DELEGATED HOUSEHOLDER DECISION

Item No. Report of the Head of Planning and Enforcement**Address** 1 BIRCHWAY HAYES**Development:** First floor side extension and demolition of existing shed**LBH Ref Nos:** 53788/APP/2016/2523

Drawing title:	
House refurbishment Flank elevation (1) New proposal	
Drawing no:	13
Revision suffix:	A
Date:	12.12.16
Drawn by:	Checked by:

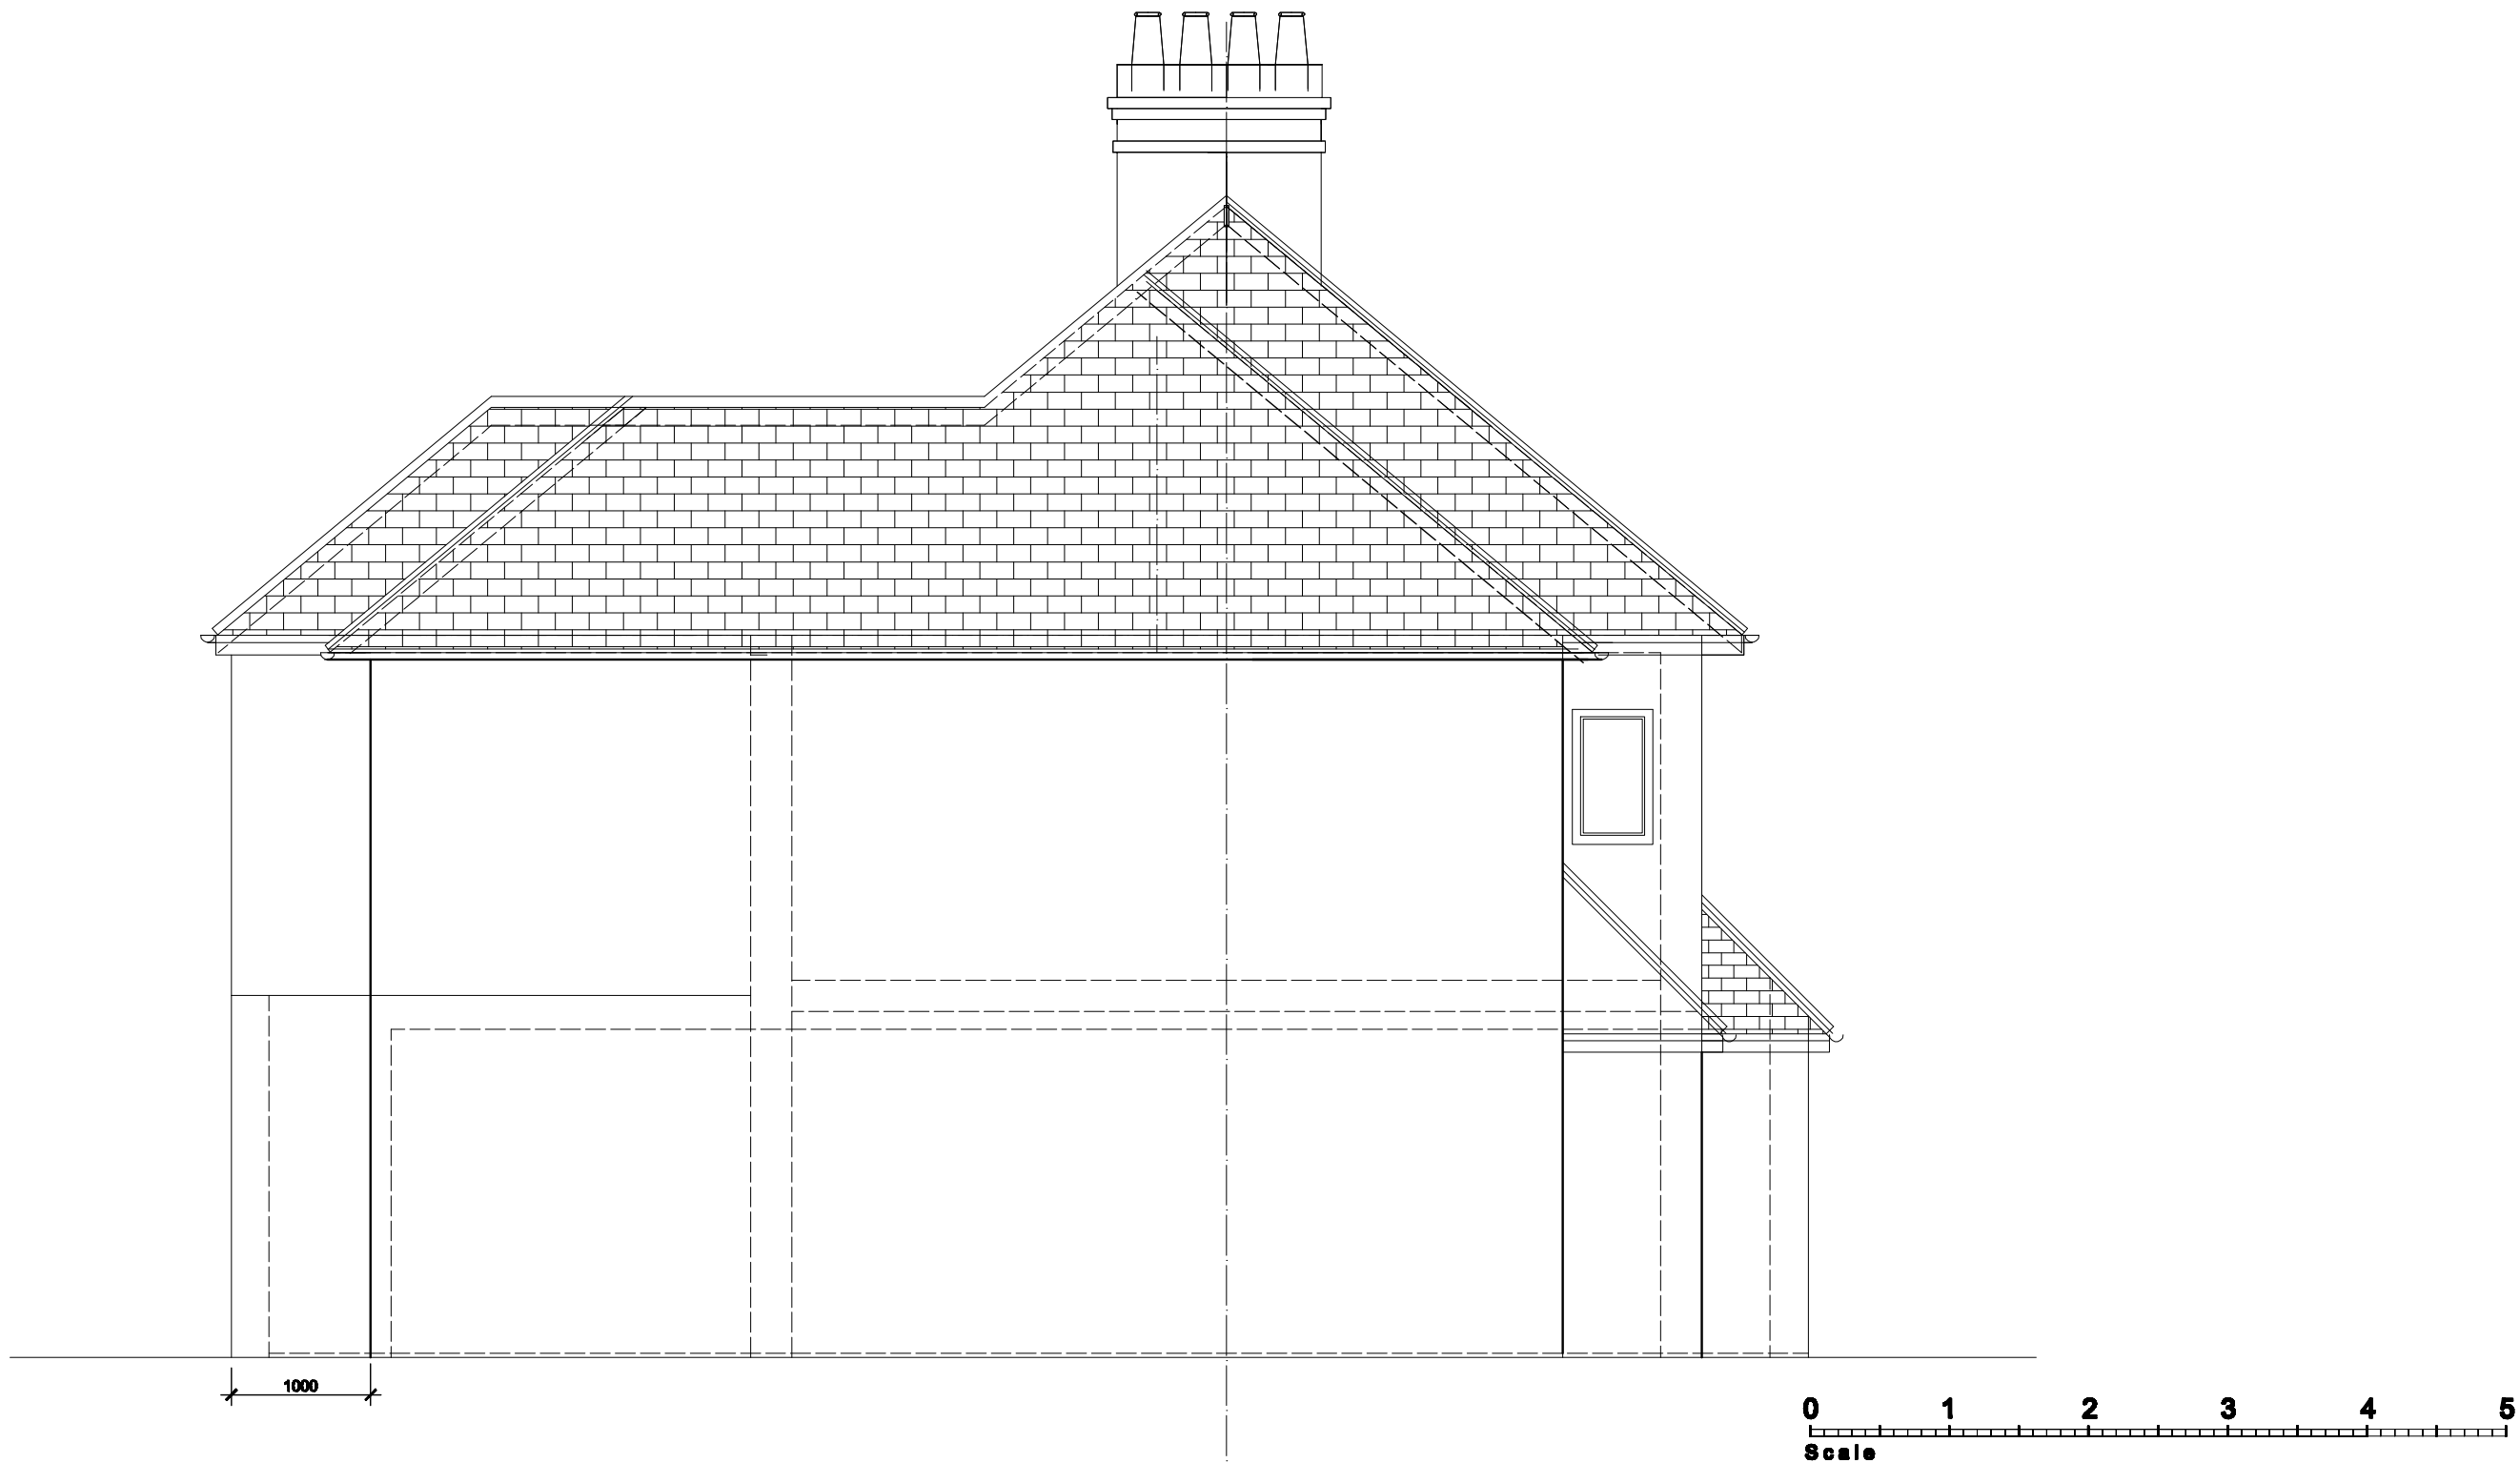
The current proposal does not fully address the Inspectors previous concerns in terms of the eaves overhang and proposes a roof design which results in an unconventional crown roof. The proposal is therefore considered to represent an incongruous addition which would be detrimental to the character and appearance of the host dwelling, the semi-detached pair, the street scene and the surrounding area generally and would thus be contrary to Policy BE1 of the Hillingdon Local Plan: Part One - Strategic Policies (November 2012), Policies BE13, BE15 and BE19 of the Hillingdon Local Plan: Part Two - UDP Saved Policies (November 2012) and the adopted Supplementary Planning Document HDAS: Residential Extensions.

The proposed first floor side extension, by virtue of its siting, size, scale and roof design would represent an incongruous form of development which would fail to harmonise with the architectural composition of the original semi-detached dwelling, would be detrimental to the character, appearance and symmetry of the pair of semi-detached houses of which it forms a part and to the visual amenities of the street scene and the surrounding area. Therefore the proposal would be contrary to Policy BE1 of the Hillingdon Local Plan: Part One - Strategic Policies (November 2012), Policies BE13, BE15 and BE19 of the Hillingdon Local Plan: Part Two - Unitary Development Plan Saved Policies (November 2012) and the adopted Supplementary Planning Document HDAS: Residential Extensions.
